City of Albuquerque Stormwater Construction Site Inspection Report

Project Name:	Cannady Self Storage			
Location:	2100 Ladera Dr NW			
Site Contact Name & Agency	Devin Cannady devin@cannadystudio.com	ESC File No.	H09E001F	
		NPDES Id. No.	NMR1001lb	
Inspection Date:	03/18/19	Start/End Time:	09110/0930hrs	
CoA Stormwater Inspector:	Timothy Sims, Stormwater Inspector			
Present Phase of Construction:	verticle, metal building			
Type of Inspection:	<input type="checkbox"/> Regular	<input type="checkbox"/> Storm Event	<input type="checkbox"/> Post Storm Event >0.25"	<input checked="" type="checkbox"/> 311/Complaint <input checked="" type="checkbox"/> Follow Up

### Erosion Control Notes

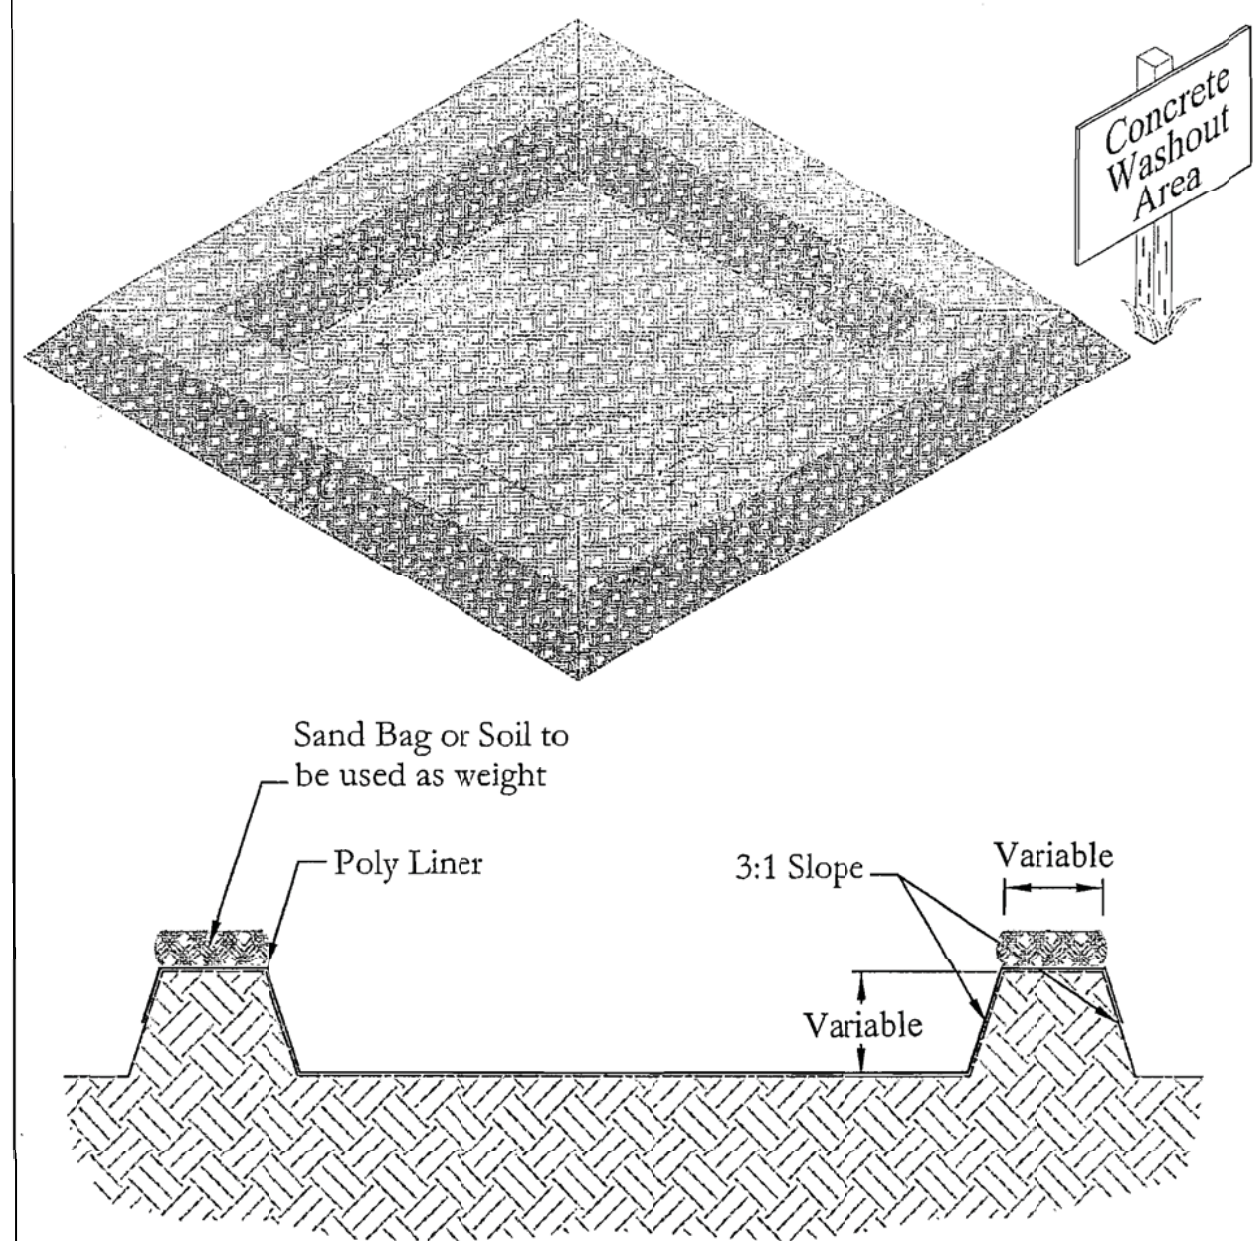
2.2.3	Sediment control along any perimeter	x	SE corner of site dirt pile >50% of silt fence height
2.2.3			remove dirt pile to <50% - clean
2.2.3	Sediment control along any perimeter
